Please ask for: Mrs D Johnson
Email: daun.johnson@arun.gov.uk
Telephone: 01903 737762
Our Ref: K/6/22/PL
Your Ref:
Date: 23rd February 2022

Application for Planning Permission

Development: Erection of a detached dwelling and integral garage (resubmission following K/51/21/PL). This application is in CIL Zone 4 and is CIL Liable as new dwelling.
Location: 47 Golden Avenue East Preston BN16 1QX

GROUND FLOOR

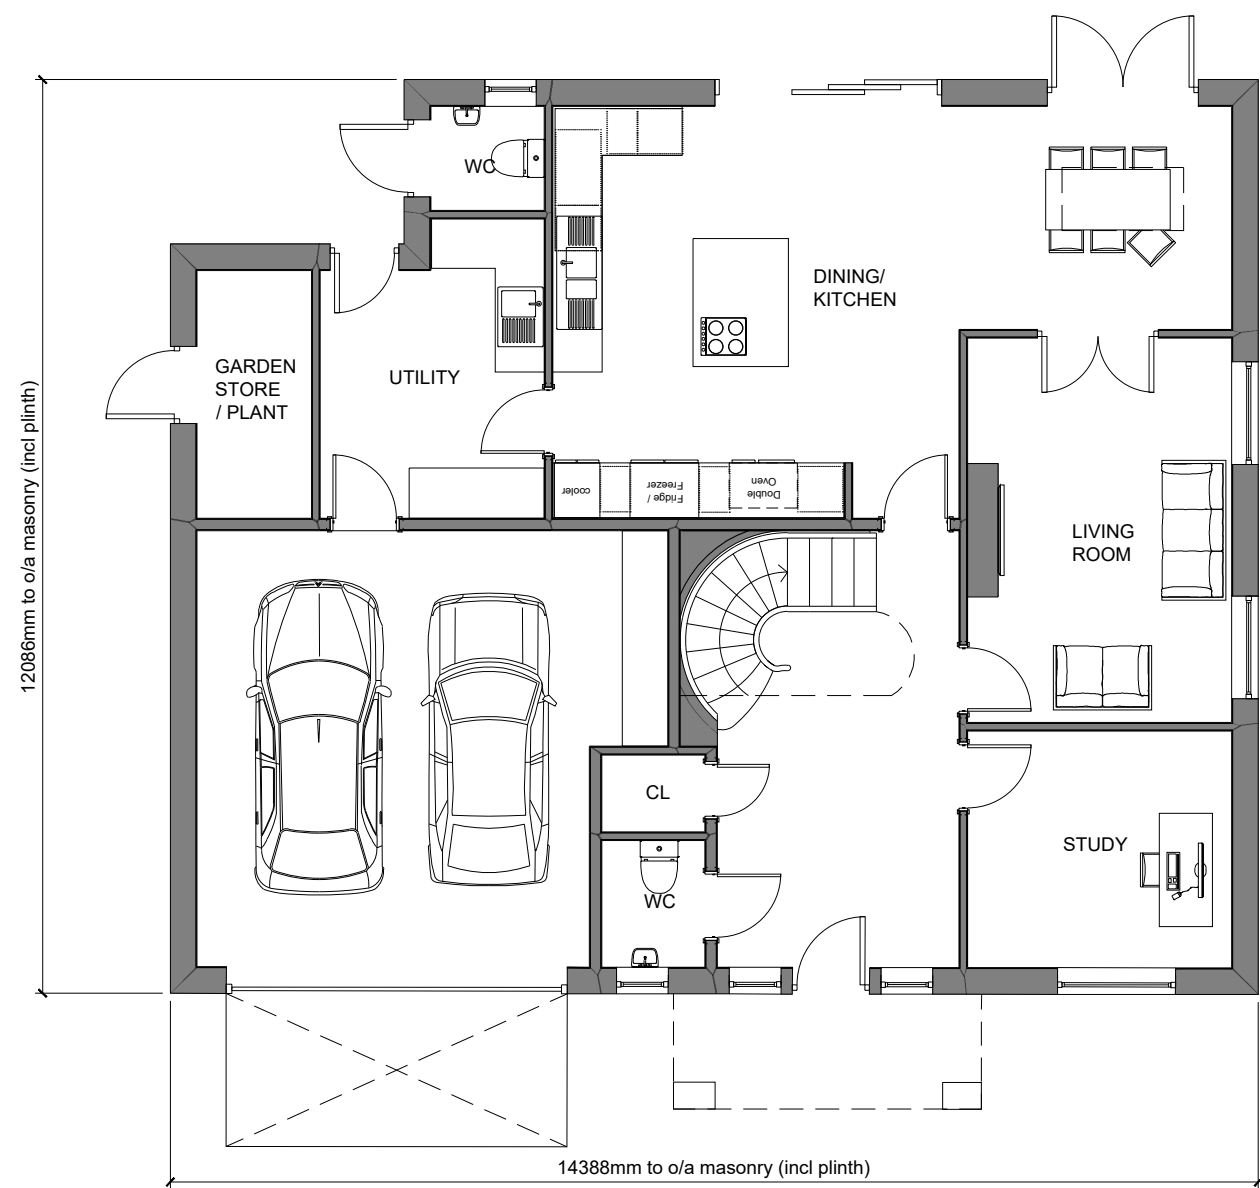
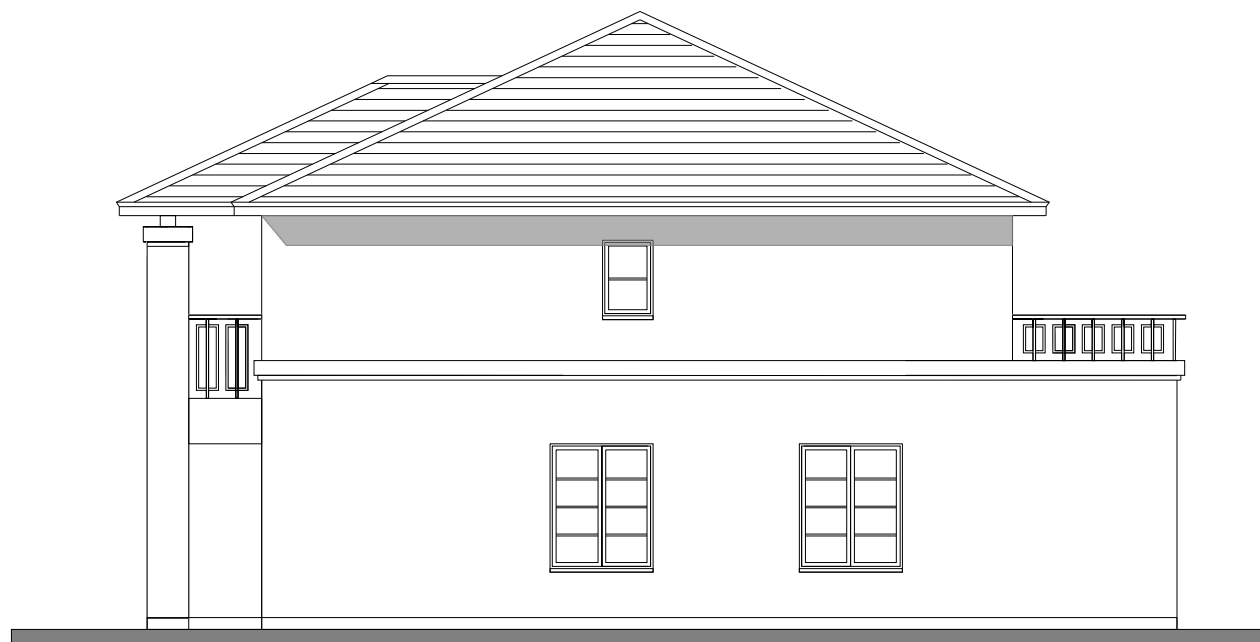
The ground floor plan and side elevation do not accord. Please amend accordingly.
